September 16, 2021

Re: Letter of Intent for Colorado Springs Utilities Northeast Gravel Staging Area

ATTACHMENT 2 – Site Plan Drawing

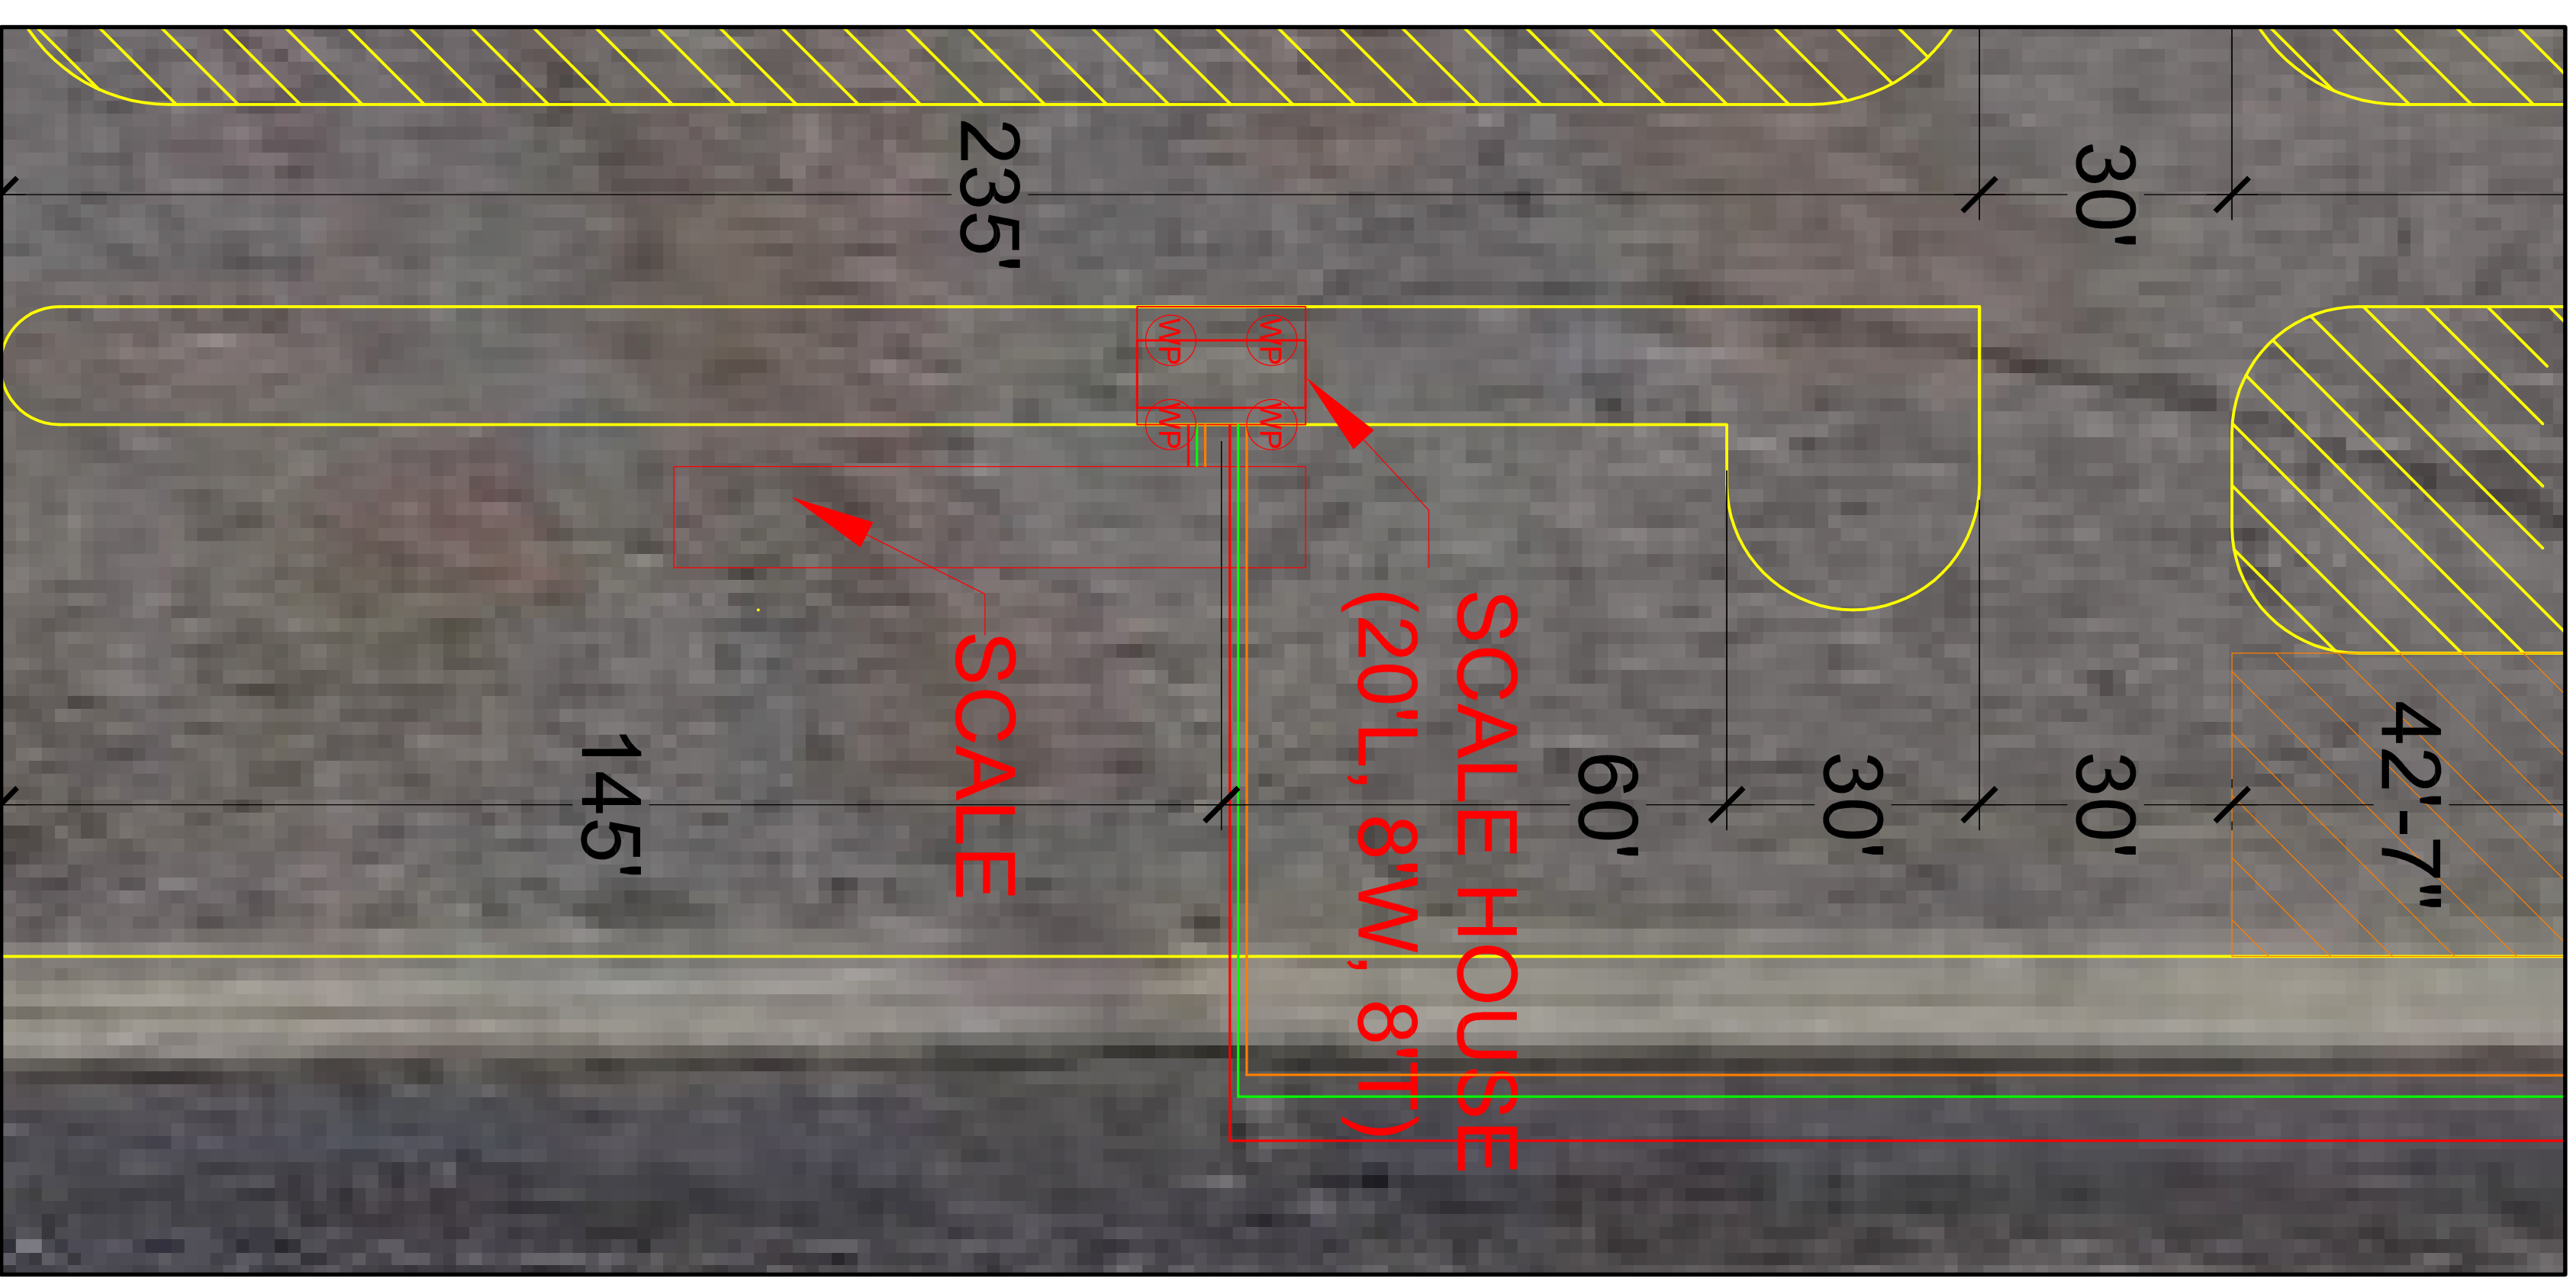
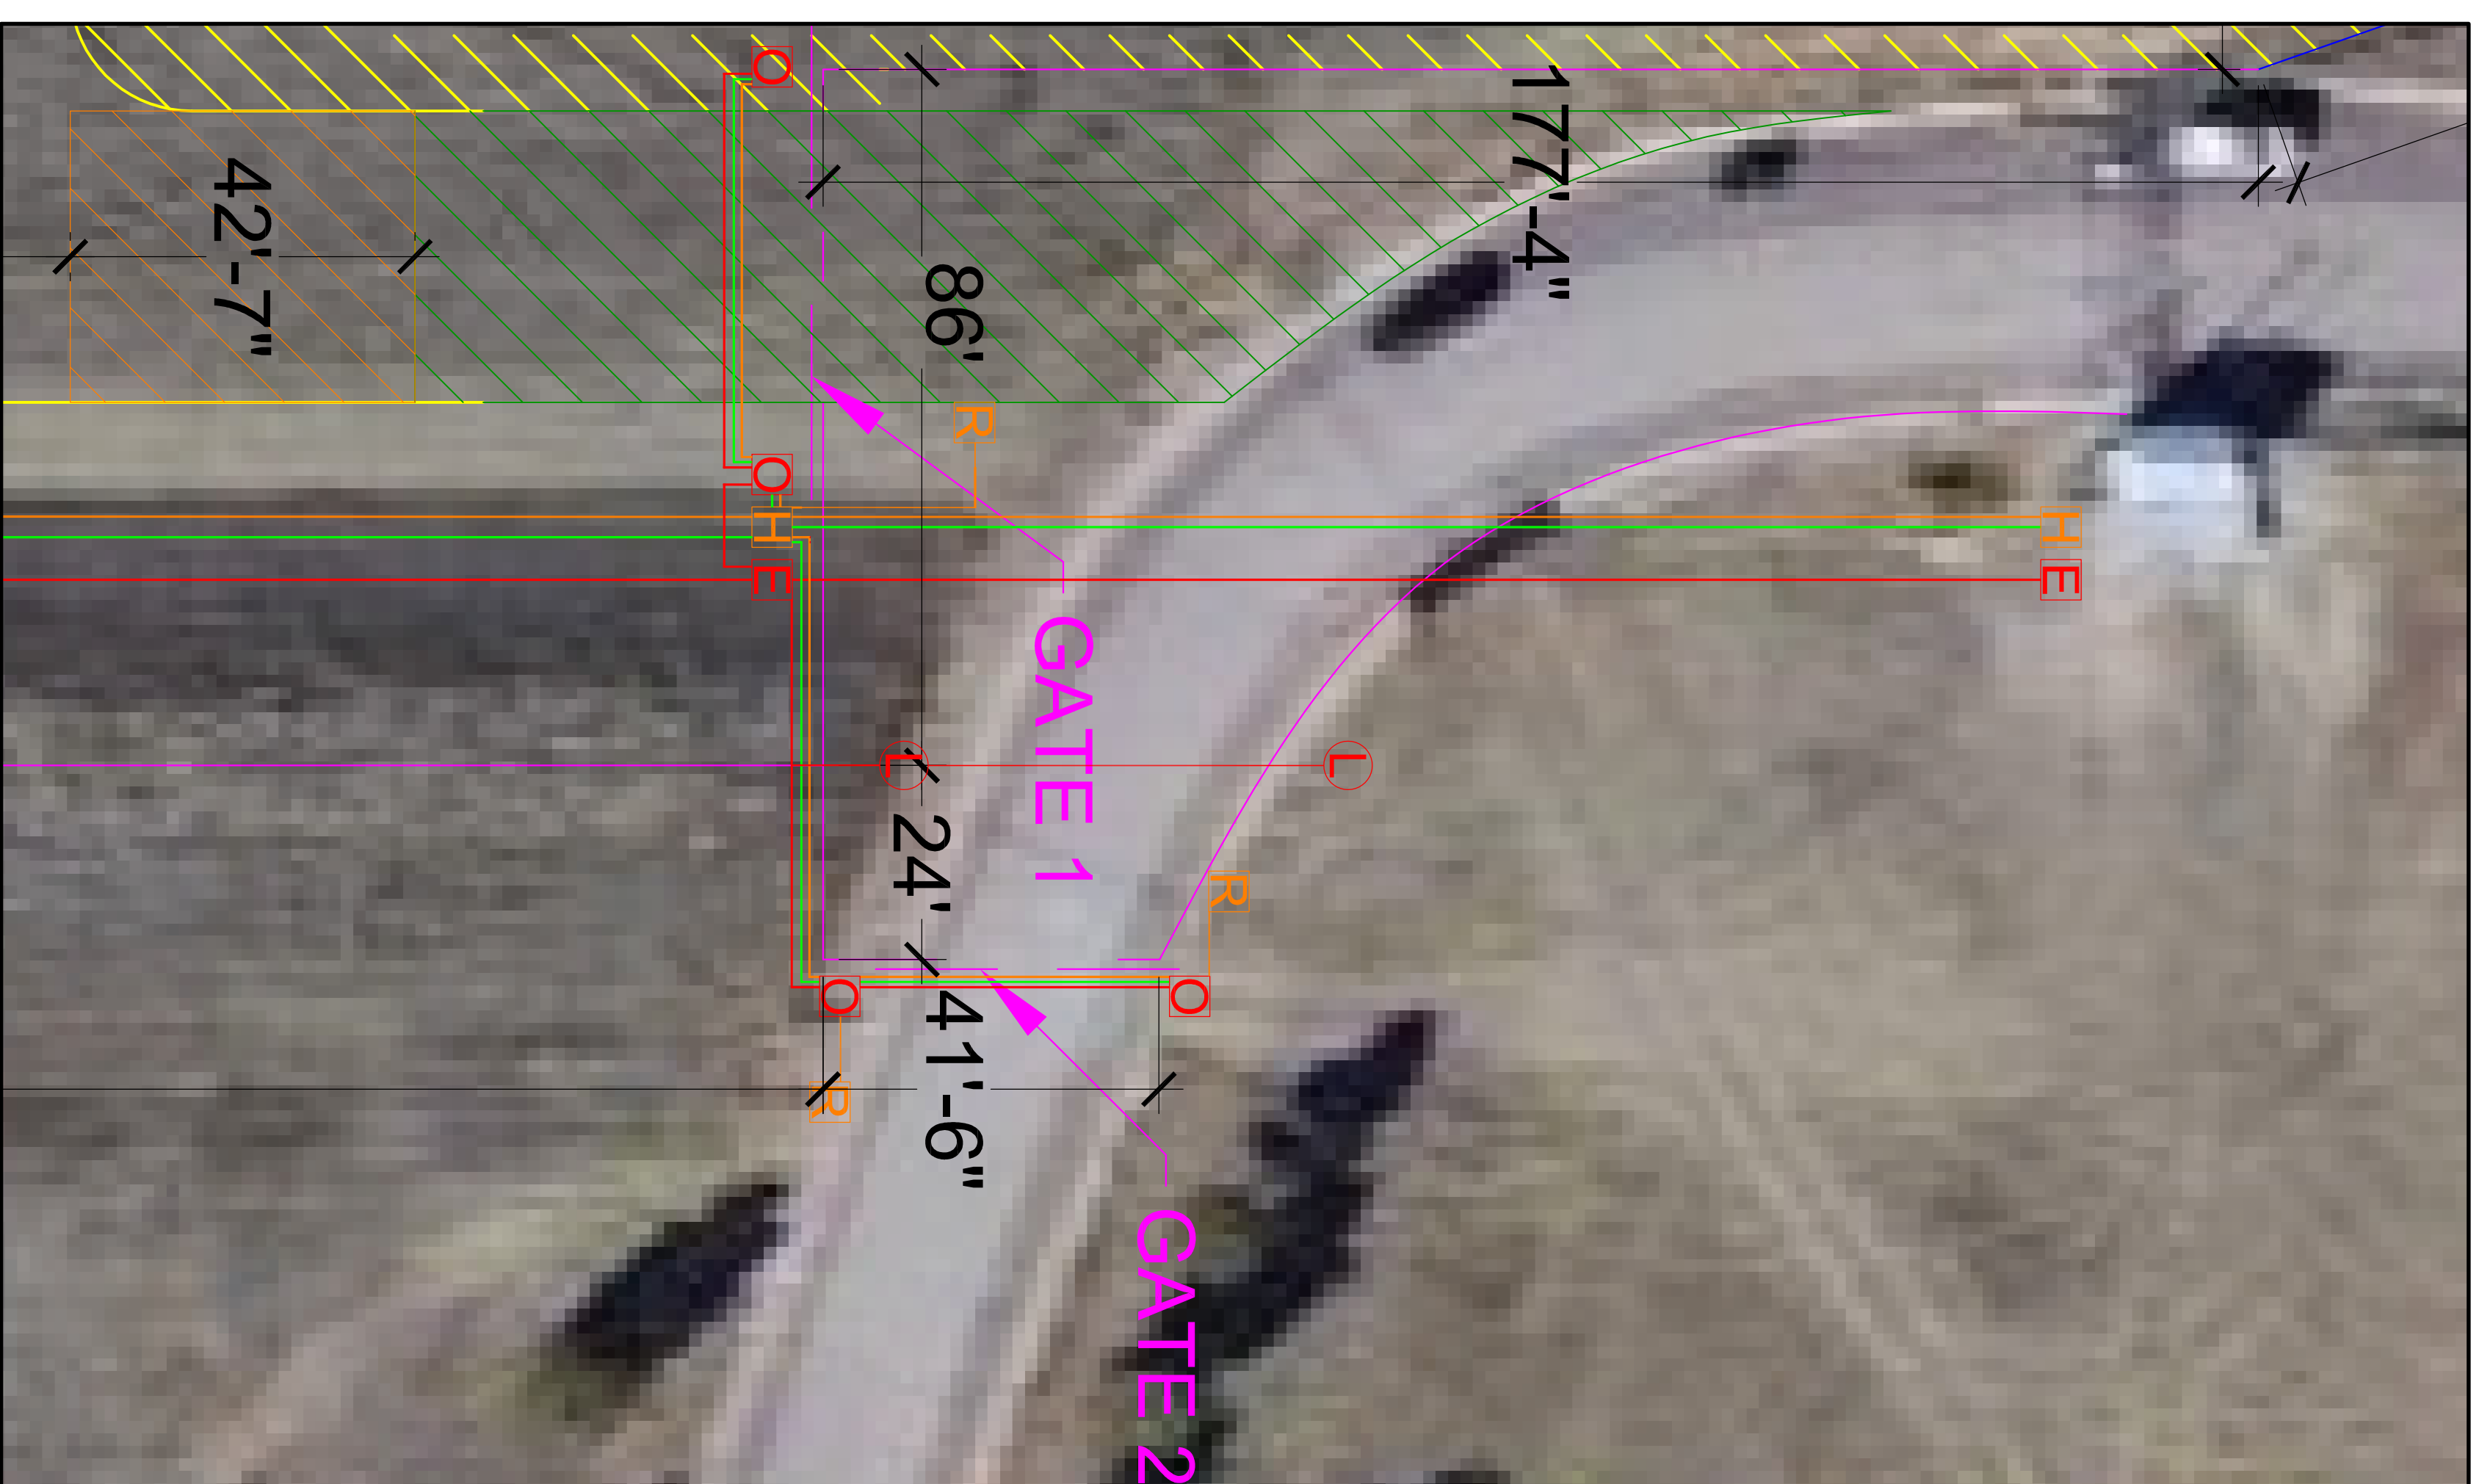
Please provide revisions according to comments on site plan and traffic report.
